116-0549-10

Application for a non-material amendment following a grant of planning permission.

CHANGE OF USE OF VETERINARY PRACTICE TO FORM 2 FLATS, ALTERATIONS
TO FIRST FLOOR TO FORM 2 FLATS AND EXTENSION TO FORM TWO
STOREY DWELLING.

NEW ROOFLIGHT OVER FLATS COMMON STAIRCASE.

|          |                                              | DRAWING NO | 07135_005.      |

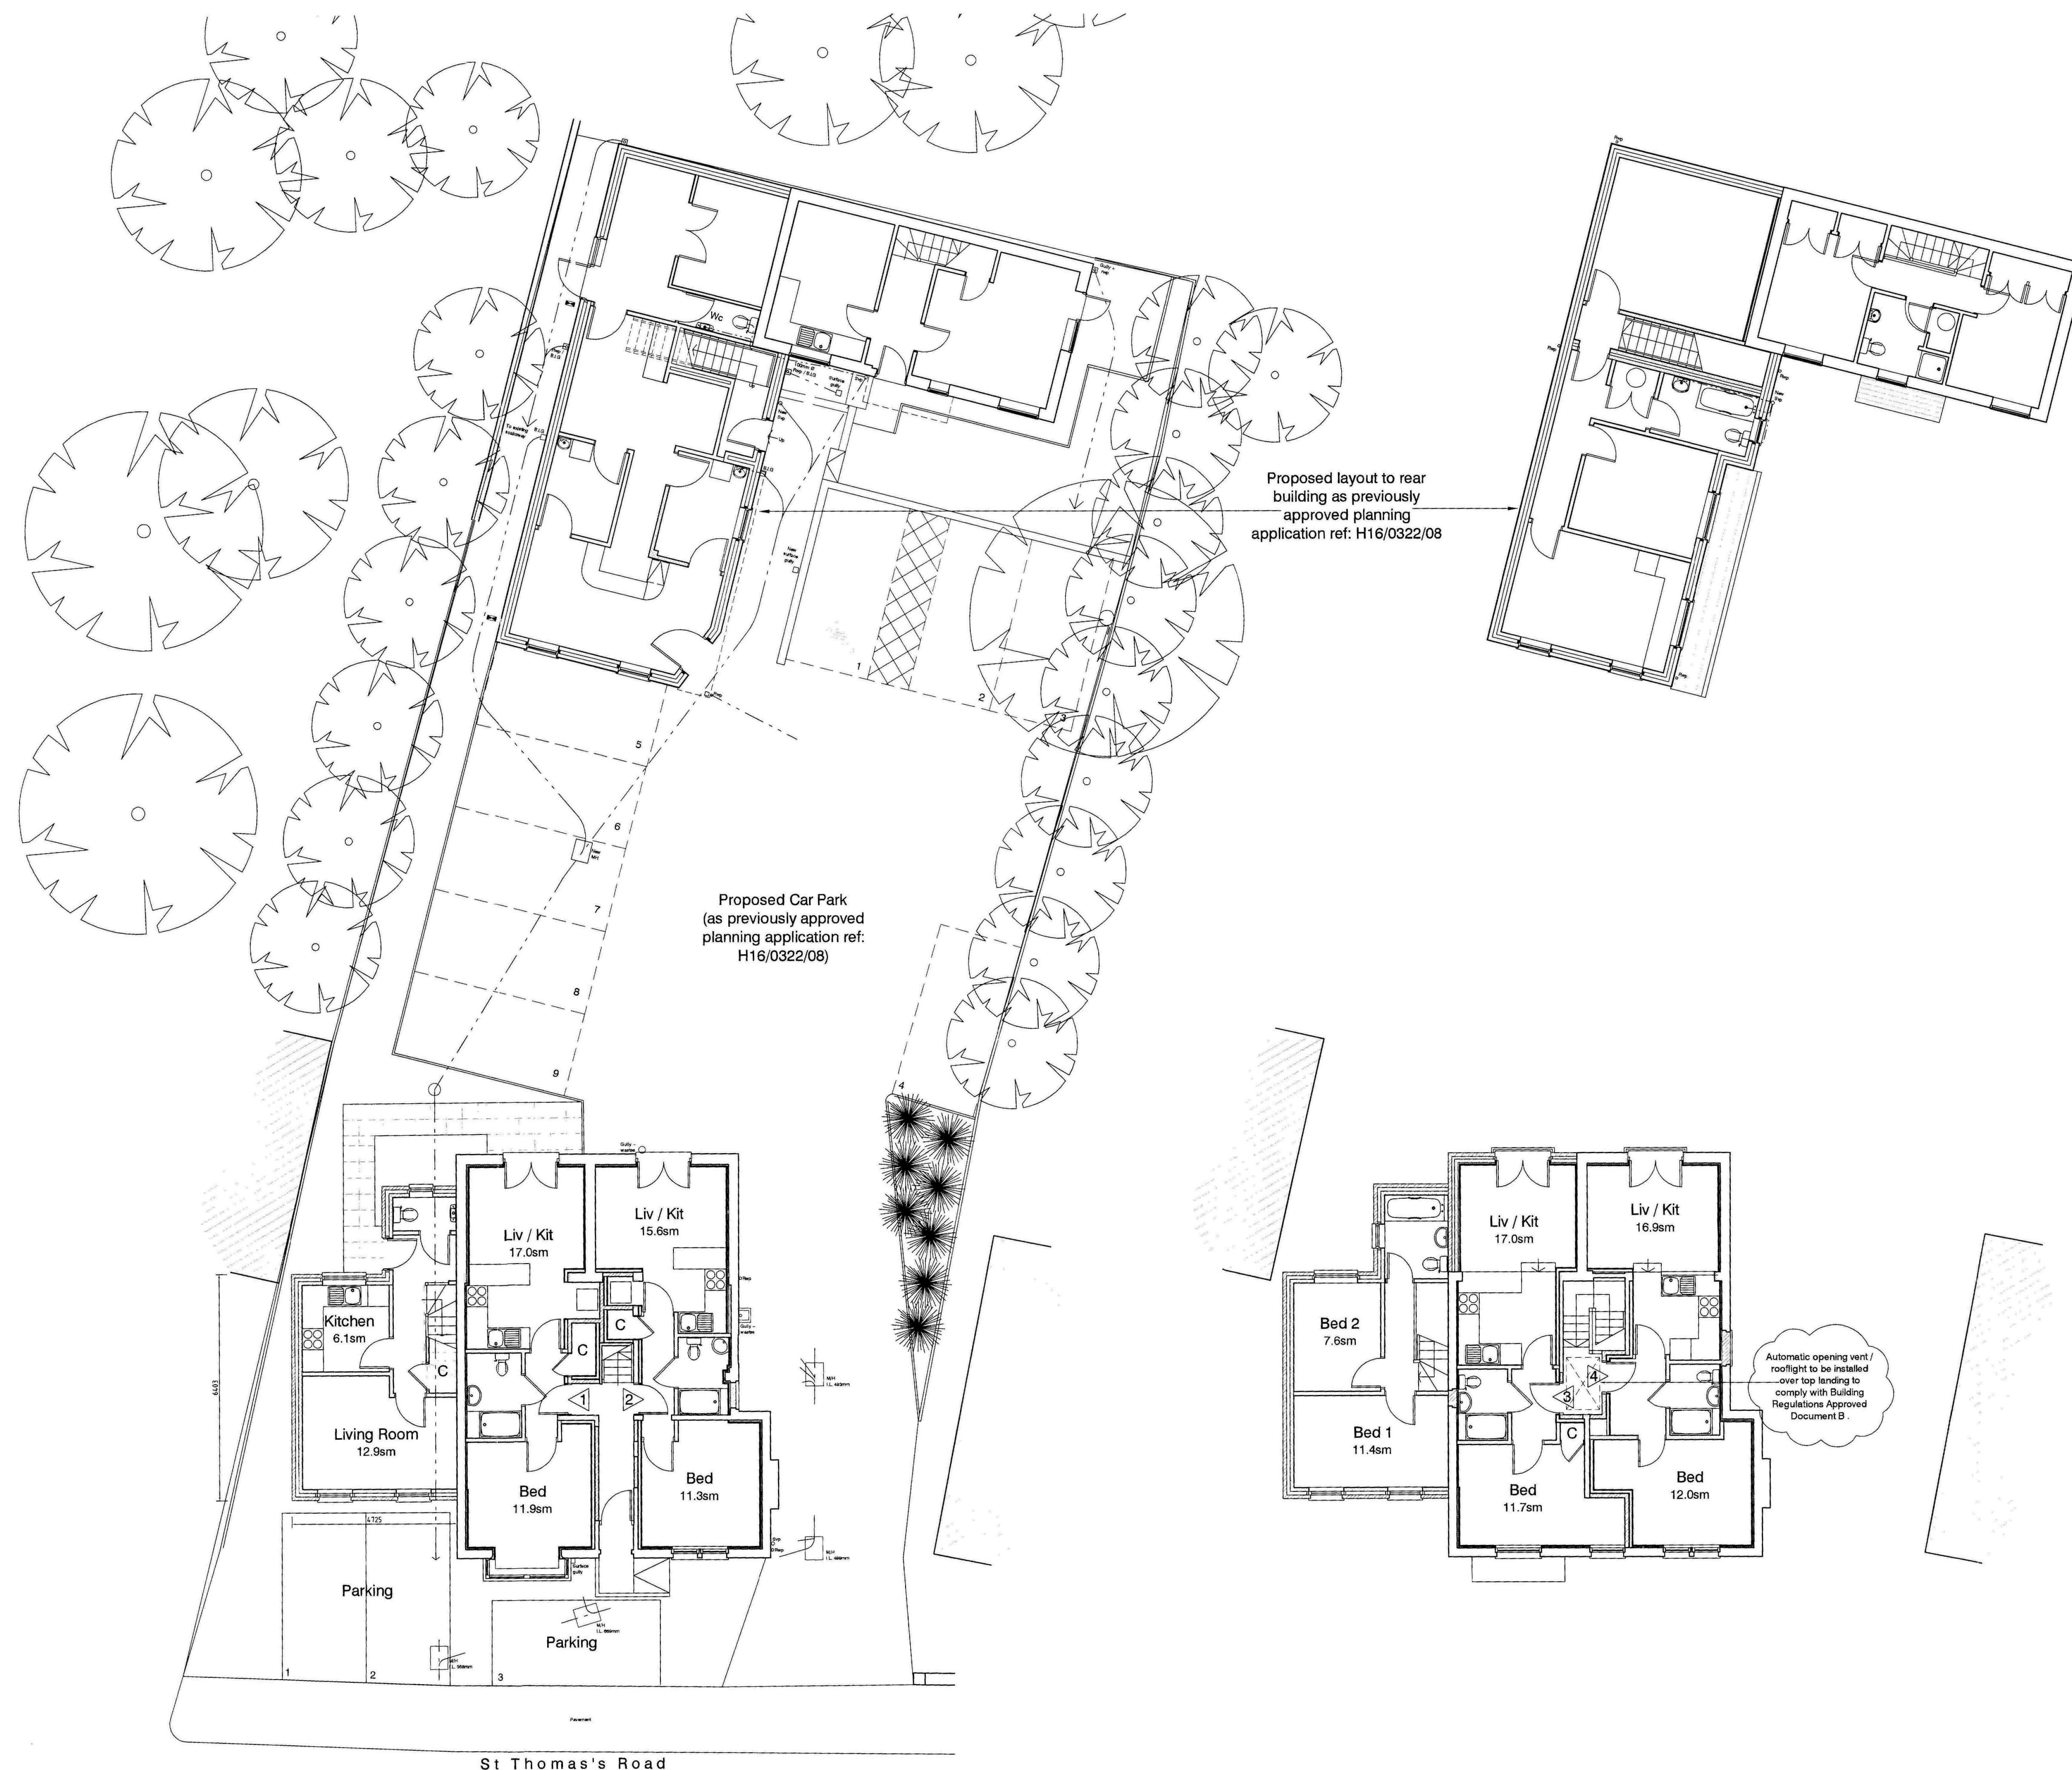
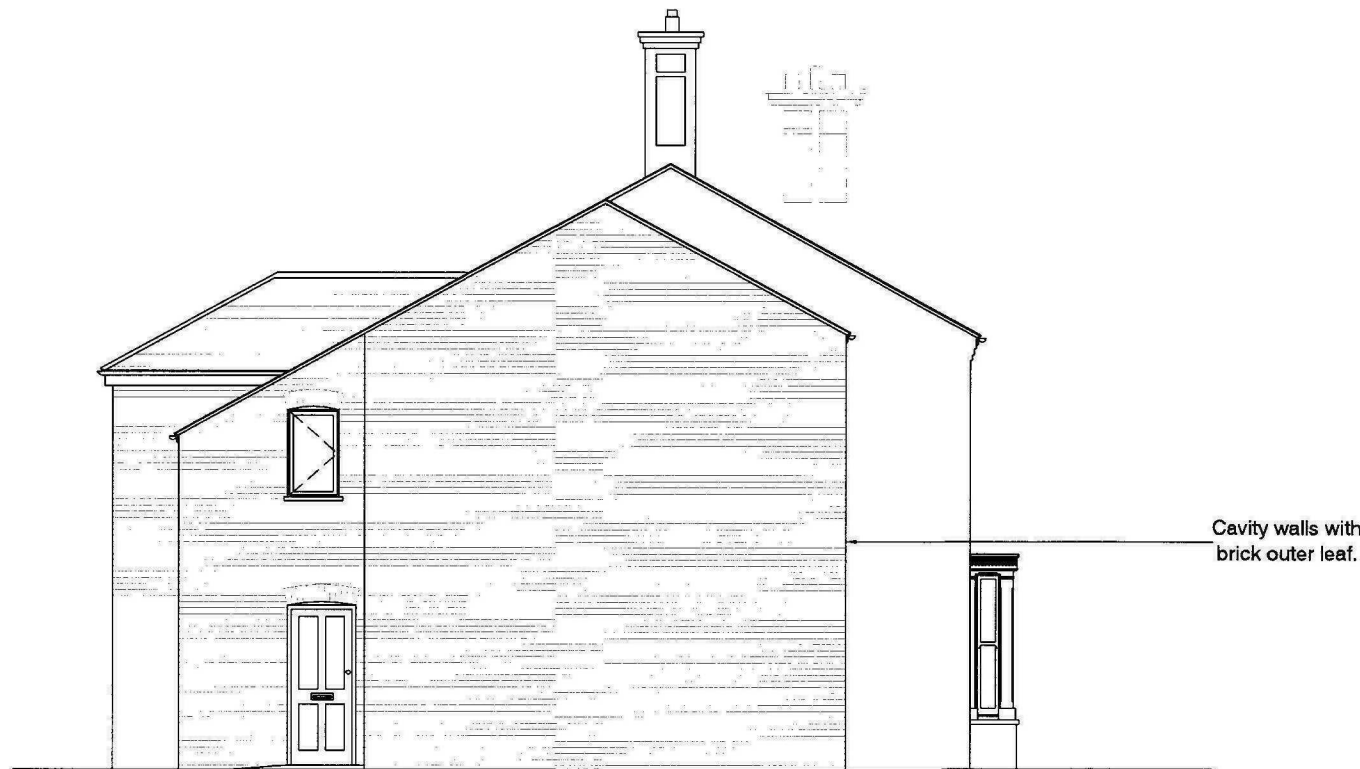
AN AUTOMATIC OPENING SMOKE VENT IS REQUIRED OVER THE STAIRCASE
AS PER BUILDING REGULATIONS APPROVED DOCUMENT B - VOLUME 2.
